KIRKLEES METROPOLITAN COUNCIL INVESTMENT & REGENERATION SERVICE

DELEGATED DECISION TO DETERMINE PLANNING APPLICATIONS

Reference No:	2024/62/92035/W
Site Address:	15, Lincroft Avenue, Dalton, Huddersfield, HD5 8DS
Description:	Demolition of existing conservatory, rear lean to and chimney and erection of single storey rear extension and raised patio
Recommending Officer:	Joanna Rednall

DECISION – CONDITIONAL FULL PERMISSION

Client		Mr Mahmud	
Job		15 Lincroft Avenue Huddersfield	
Title		Proposed Side Elevations	
Drawn By	RK	Date	July 2024
Eng. Check		Scale	1: 50
Tech. Check			
Drawing No.		Rev.	
2024 / 461 / 03

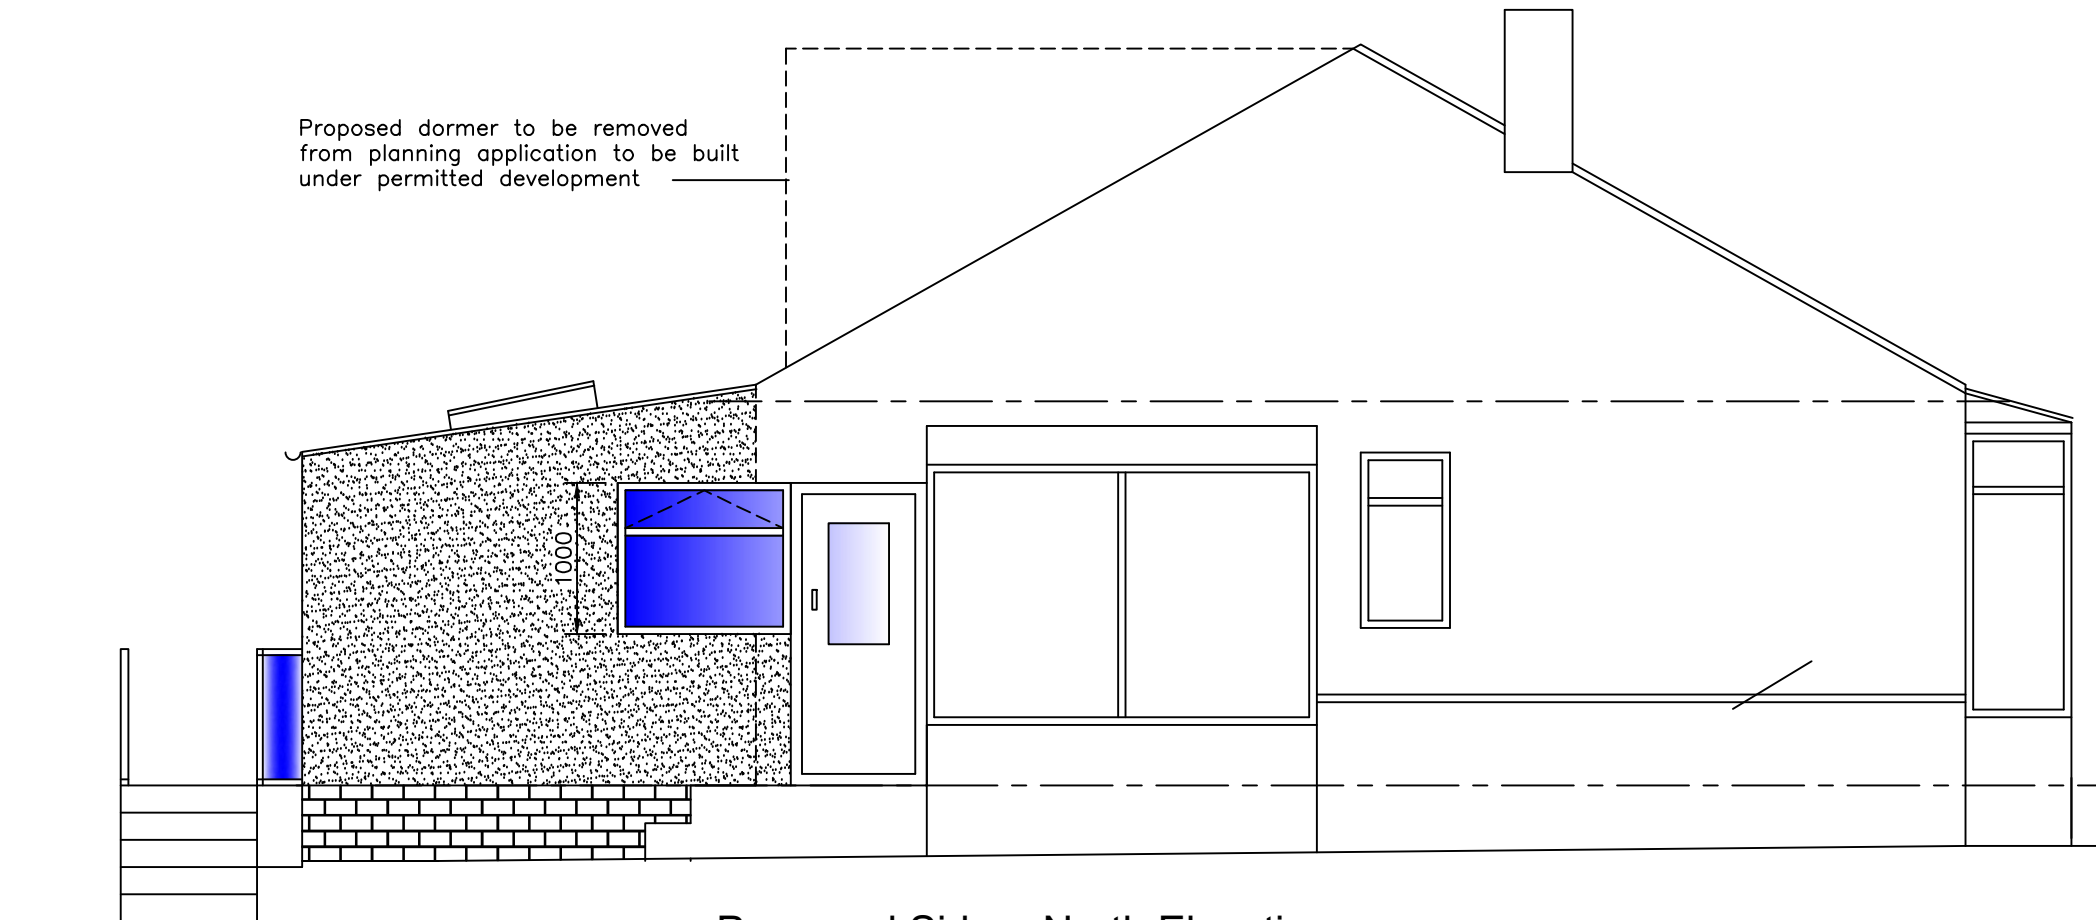
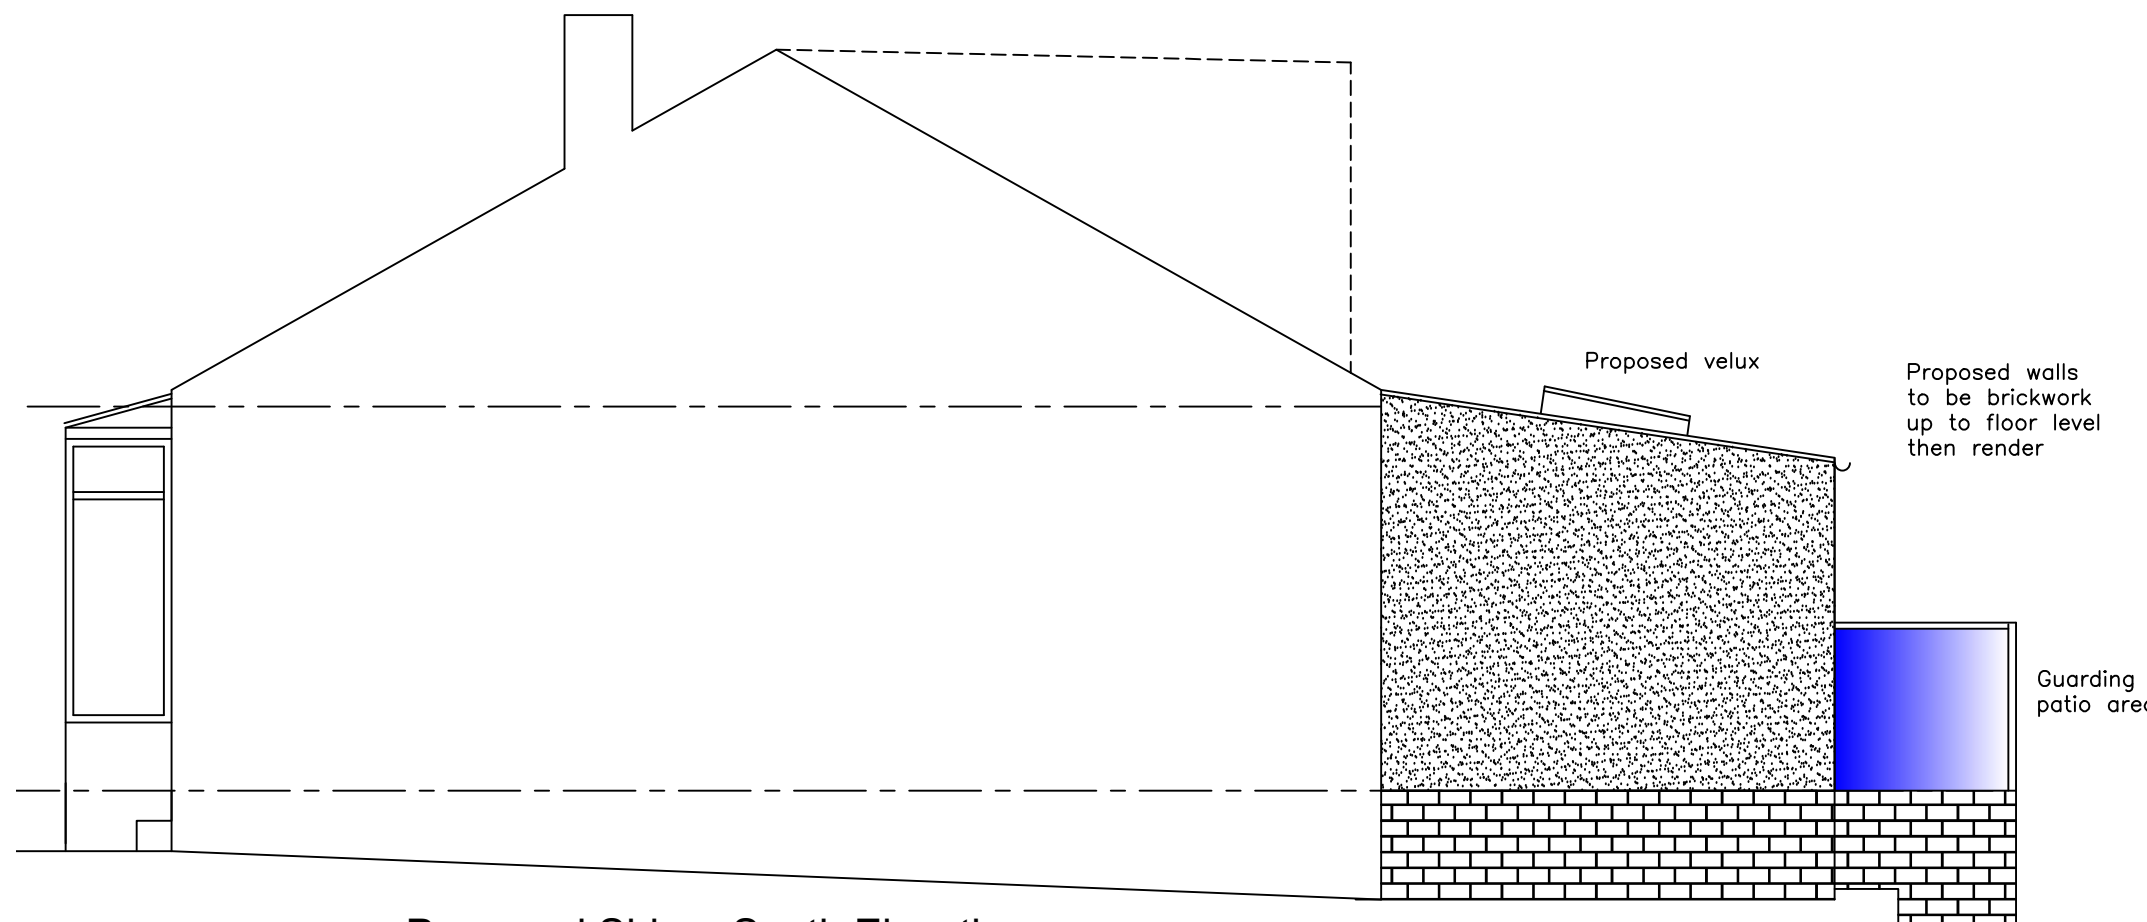
Following discussions with the applicant's agent regarding the size of the rear dormer and the ridge height of the rear extension. The dormer has been removed and the roof ridge has been reduced for the single storey rear extension, detailed within amended plans received 23rd September. Whilst the description has been amended for clarity that the application relates to the single storey extension and rear raised platform, the amended plans / description were not re-publicised as these did not fundamentally change the development applied for and the scheme as initially advertised adequately alerted the public to the nature of the proposal.

The submitted plans show the additional openings to be of a similar appearance to those that exist on the host property inserted to the side elevation, creating an active frontage overlooking Earles Avenue. Although the side elevation would not be set back from the existing building line, the property is set well back from the pavement. Given these factors, the lack of a setback to this elevation is deemed acceptable.

Client		Mr Mahmud	
Job		15 Lincroft Avenue Huddersfield	
Title		Proposed Rear Elevation	
Drawn By	RK	Date	July 2024
Eng. Check		Scale	1: 50
Tech. Check			
Drawing No.		Rev.	
2024 / 461 / 02

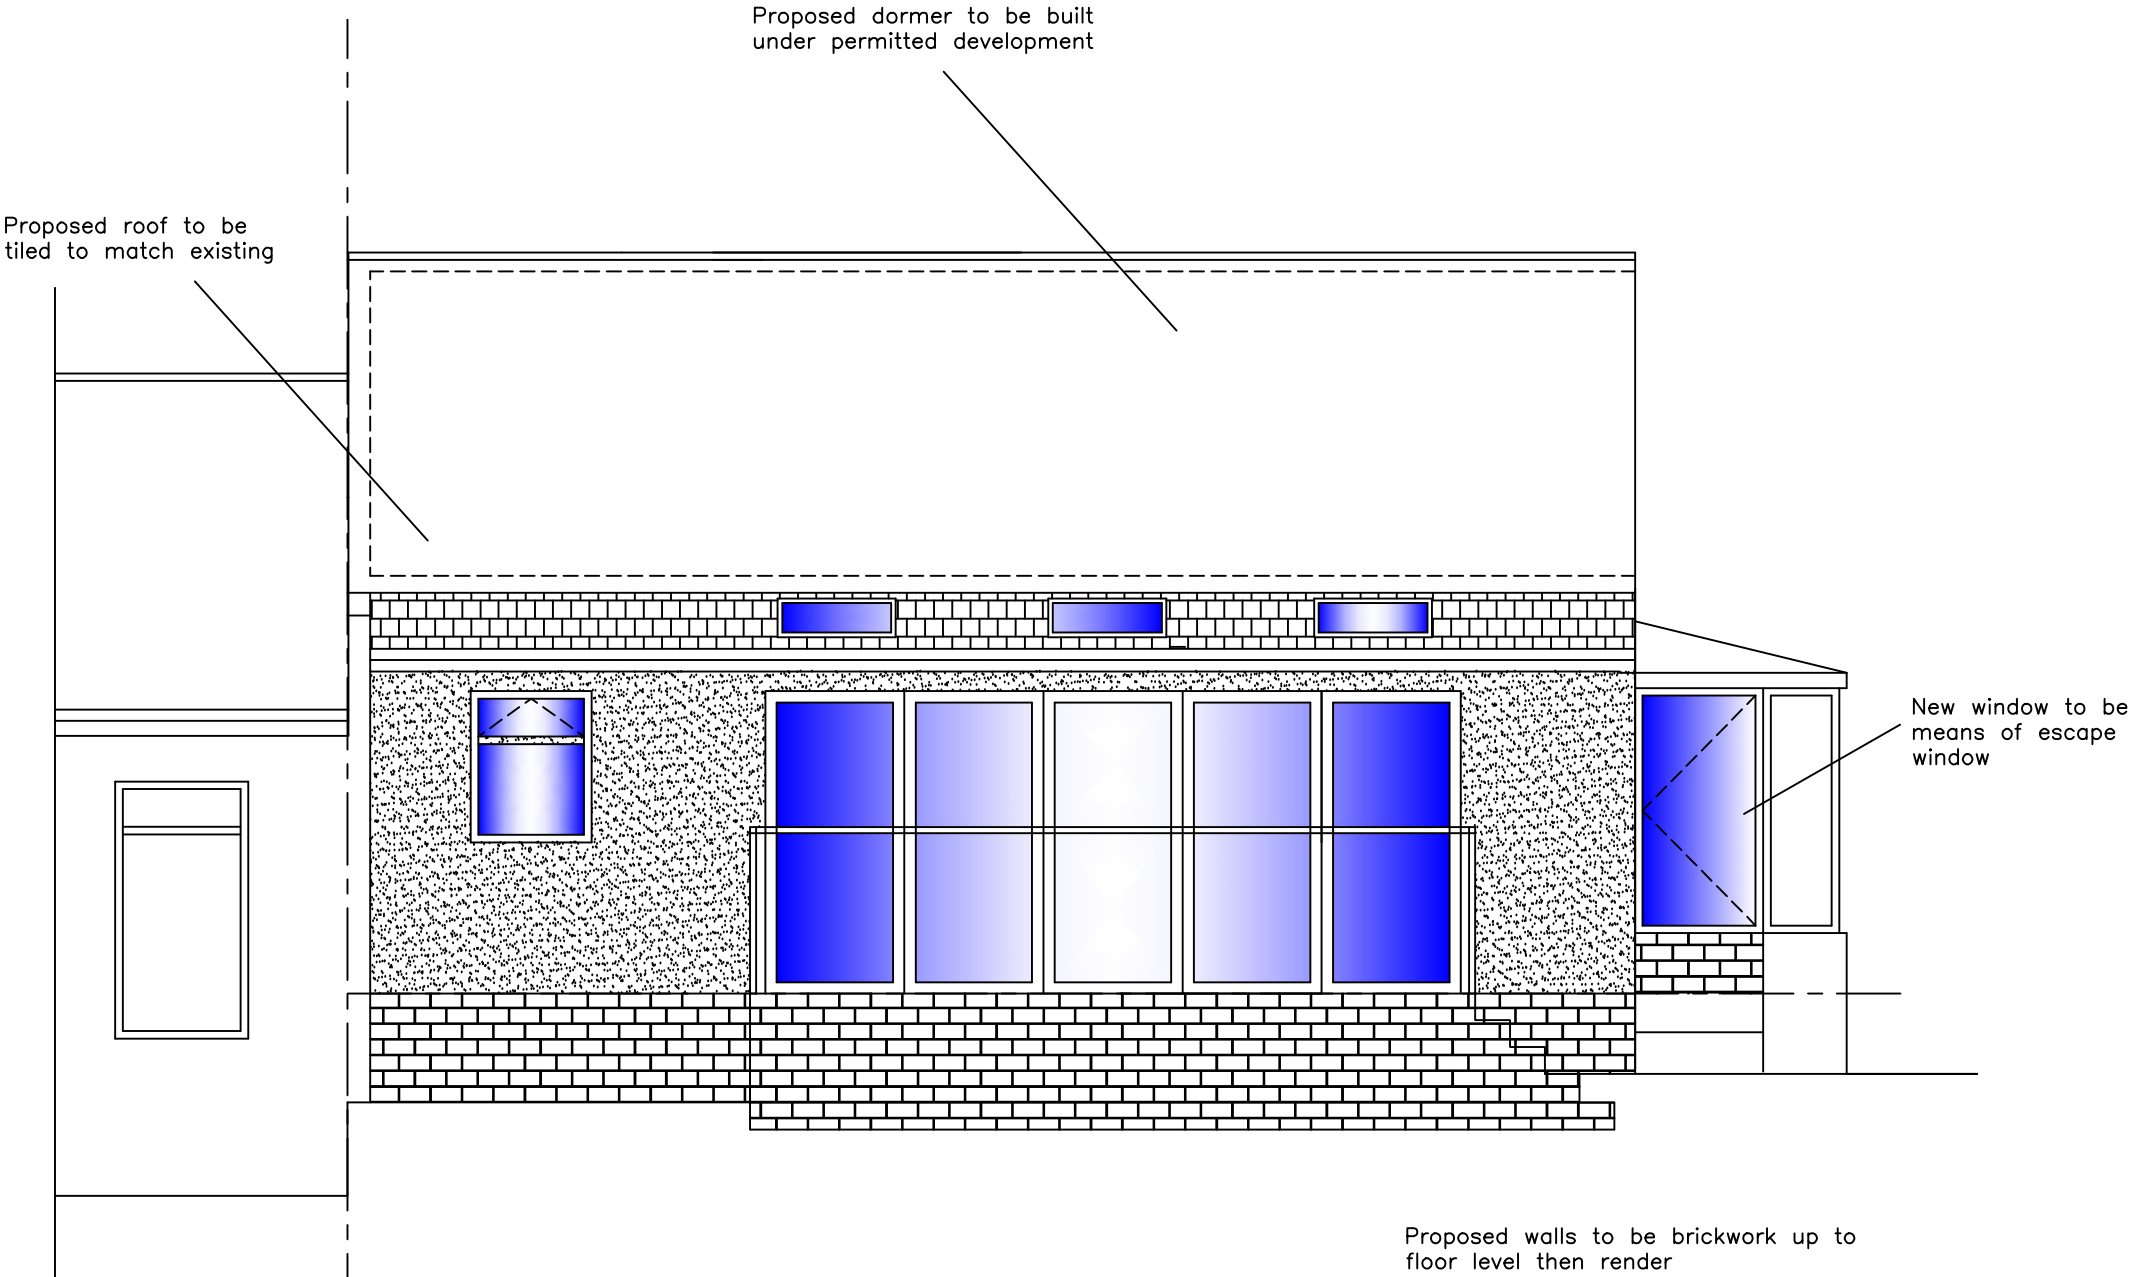
The proposed extension would increase a degree of massing closer to the shared boundary. Whilst noting that land levels drop away to the north-west the orientation of the lean-to roof would help reduce the bulk of the development when viewed from this neighbour. In addition, given the works are retained at single storey, set off the shared boundary by approx. 8.2m, and separated from this neighbour by a detached garage, the proposal is not considered to cause undue overbearing/overshadowing upon these neighbour's amenity. Any loss of privacy from the additional openings inserted into the rear elevation would not be substantial for these reasons. Therefore, any overbearing, overshadowing and overlooking would not be detrimental and can be supported.
